One Earth Solar Farm

Draft Statement of Common Ground with Bassetlaw District Council

EN010159/APP/8.5.1

July-August 2025

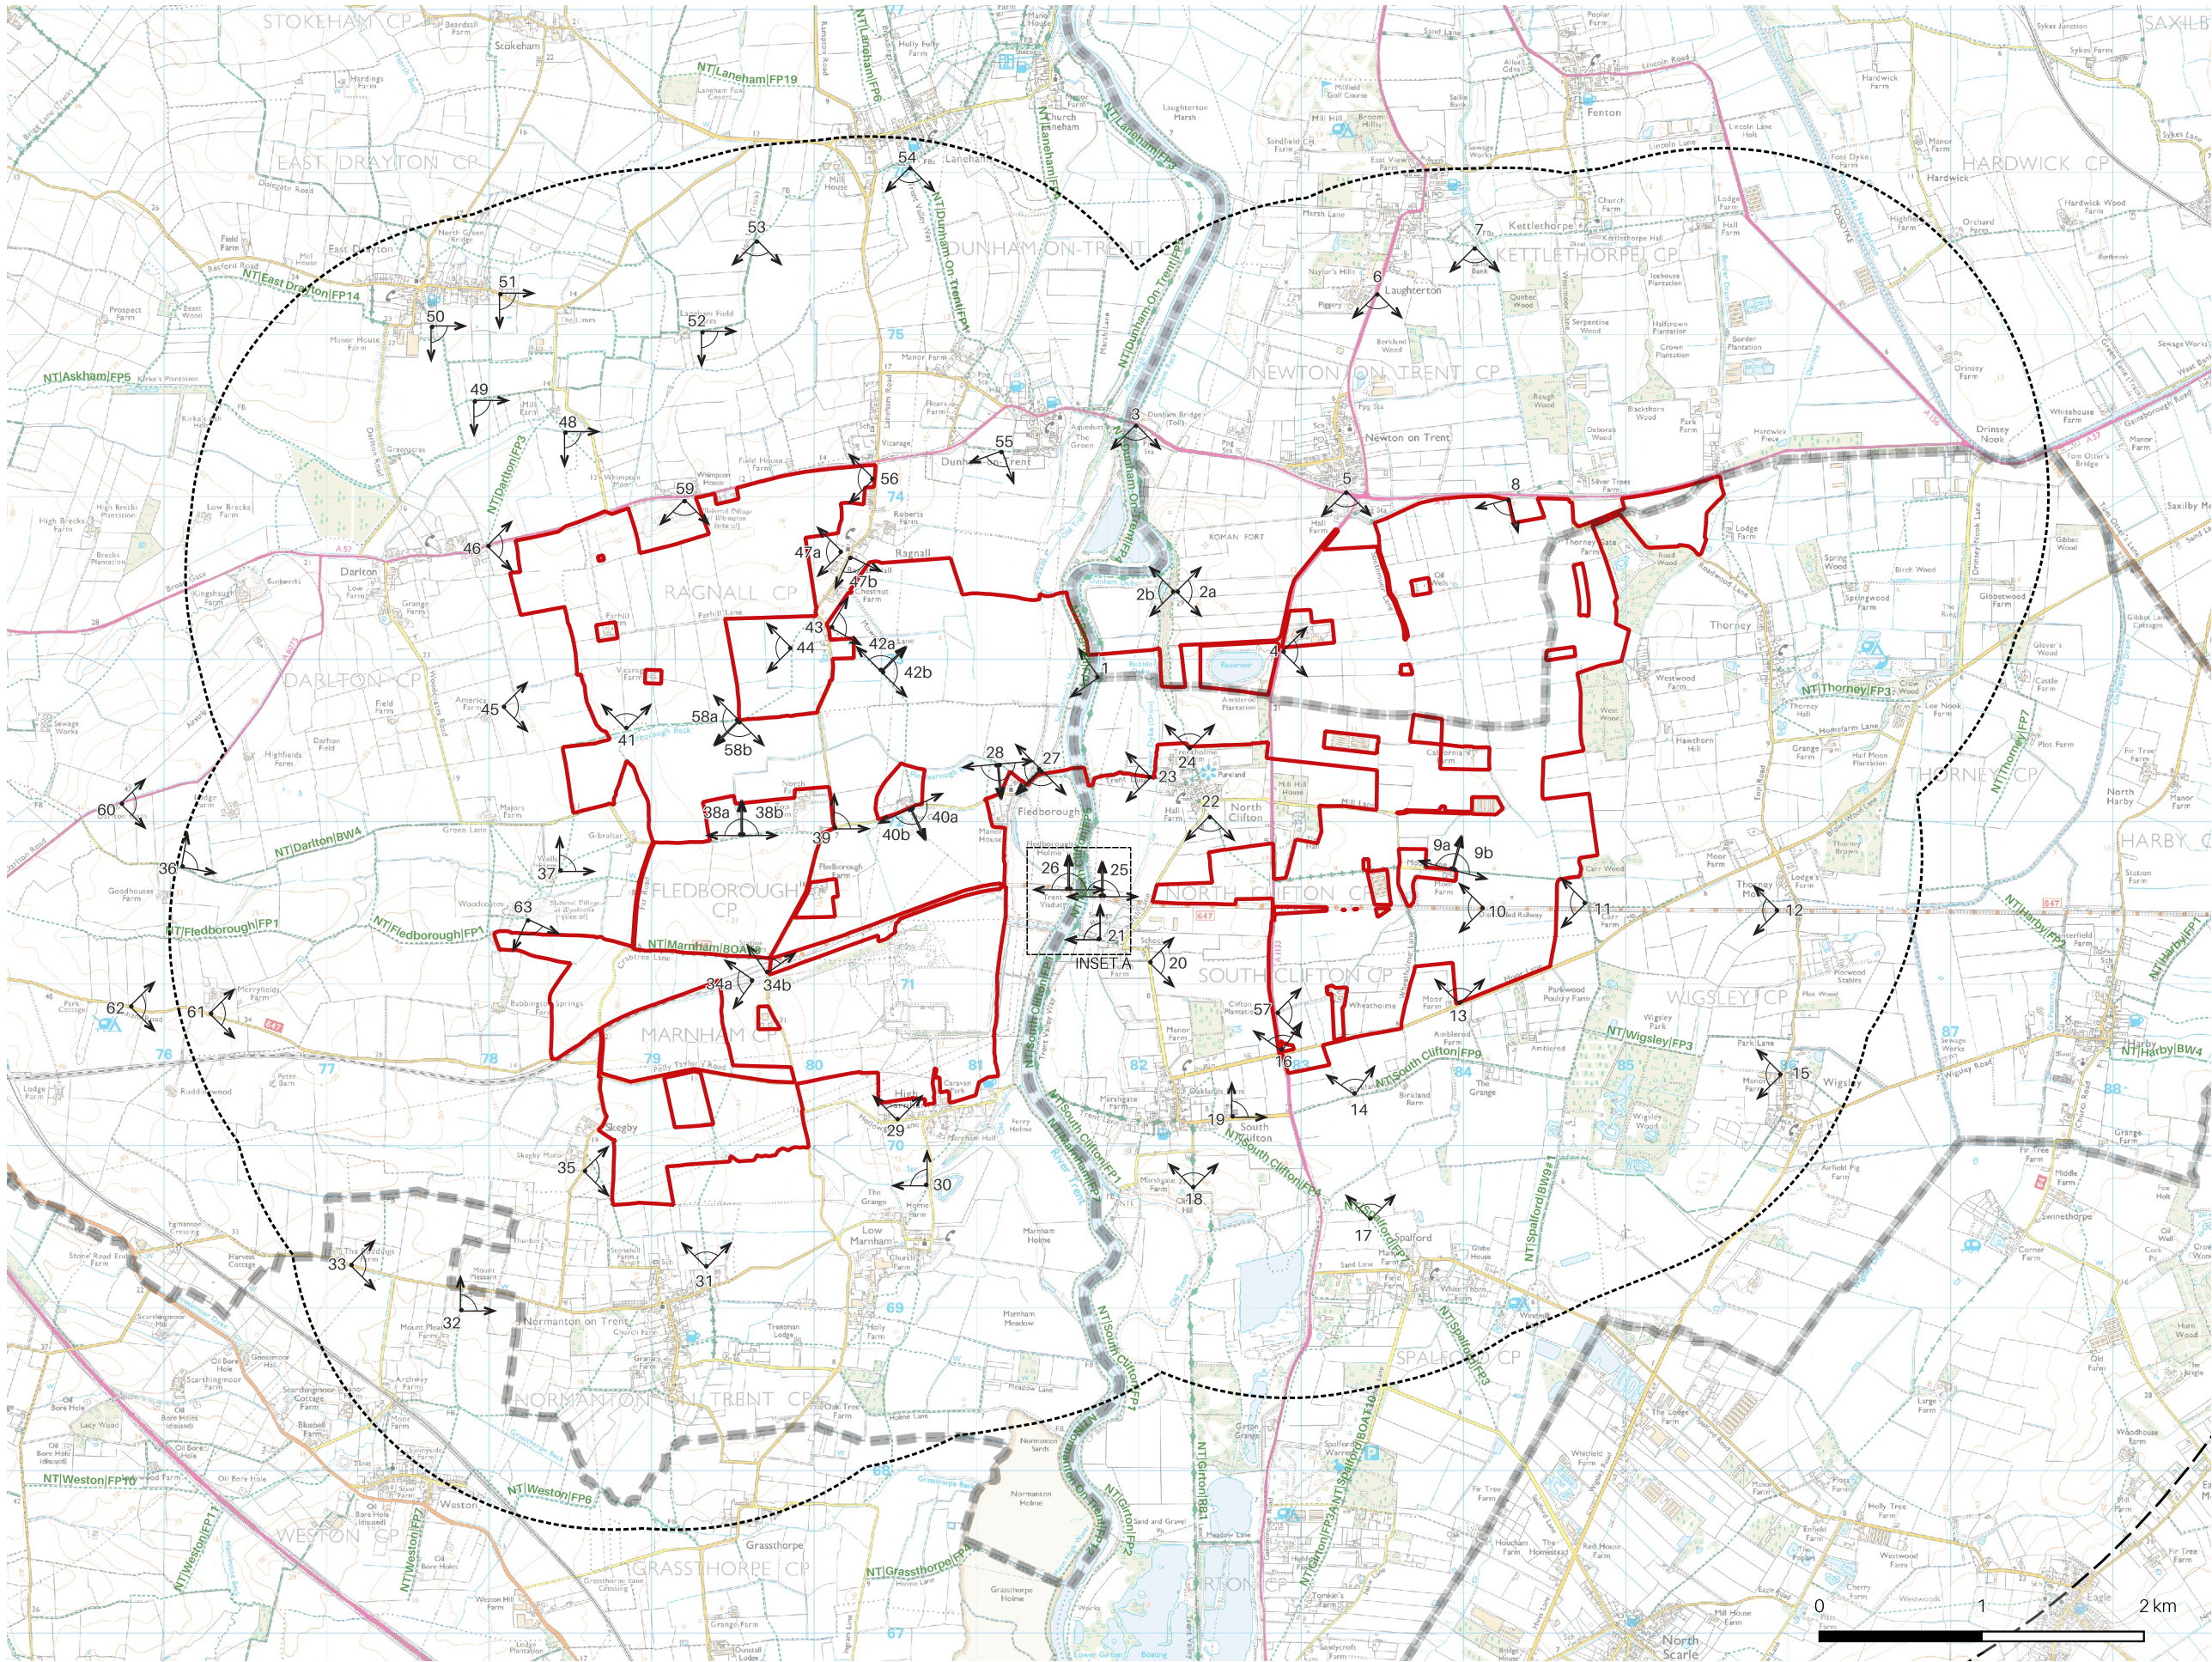
06-05	Scope of representative viewpoints	The location of some of the representative viewpoints were questioned and additional viewpoints were suggested following review of the PEIR. No further comments or concerns on the scope of representative viewpoints have been raised.	The scope of representative viewpoints is agreed. The scope of representative viewpoints was updated in the LVIA ES Chapter to include for the suggested additions and refinements.	Agreed
06-06	Scope of photomontages	An additional Type 4 photomontage was suggested from Viewpoint 58 following review of the PEIR. No further comments or concerns on the scope of representative viewpoints have been raised.	The scope of photomontages is agreed. Further discussion was had between the applicant and the District Councils during the preparation of the LVIA ES Chapter regarding the scope of photomontages resulting in agreement that the number and distribution of locations is sufficient.	Agreed

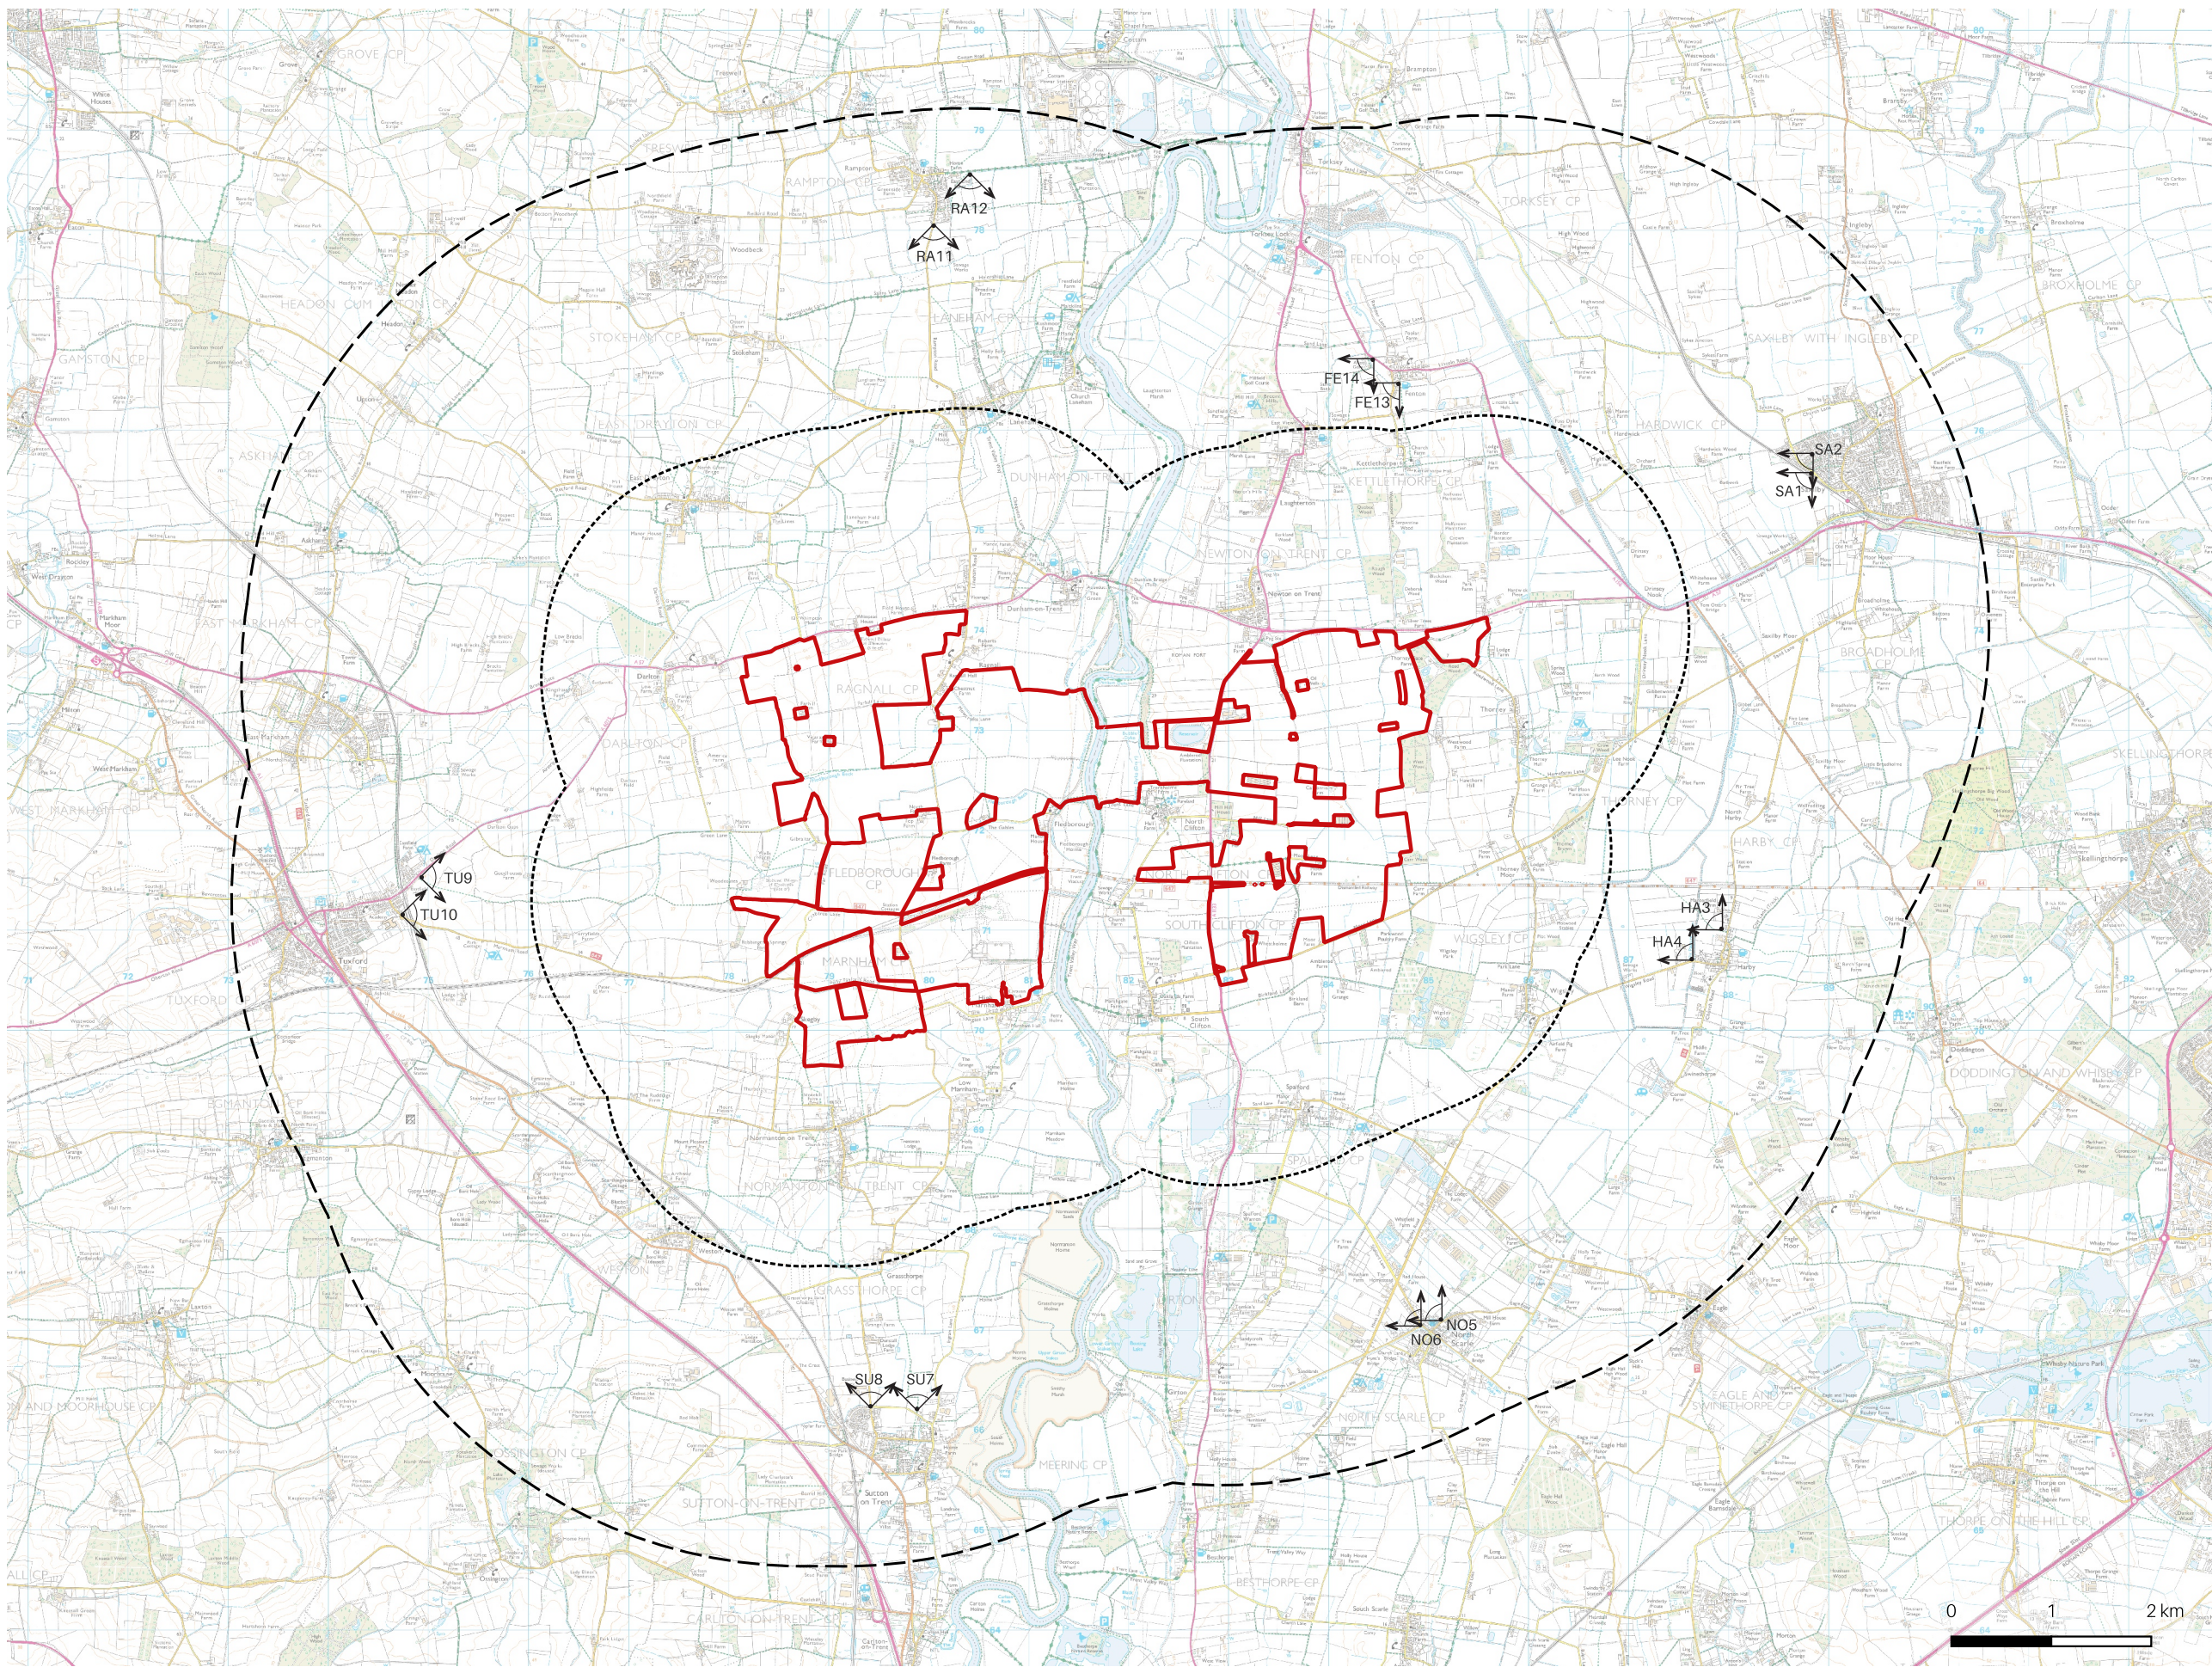
06-02	LVIA Study Area	AAH Consultants commented that effects beyond 2km had not been considered fully at the PEIR as all the proposed viewpoints were located within the 2km LVIA Study Area, despite the ZTV showing the potential for visibility beyond 2km. In response, photographs from 8 locations were provided by the applicant to test the judgement of no significant visibility beyond 2km. AAH Consultants welcomed these photographs but questioned the location of some of them in terms of representativeness of the receptor.	The LVIA 2km Study Area is agreed following a site visit between the applicant and AAH Consultants on 25th June 2025 which included visiting several of the locations of the supplementary photographs previously provided, confirming that they are representative.	Agreed
06-03	Scope of landscape receptors	The inclusion of Thorney as a Local Village Character Area following feedback on the PEIR was welcomed. No further comments or concerns on the scope of landscape receptors have been raised to date.	The scope of landscape receptors is agreed. The scope of landscape receptors was updated in the LVIA ES Chapter to include for the suggested additions and refinements.	Agreed
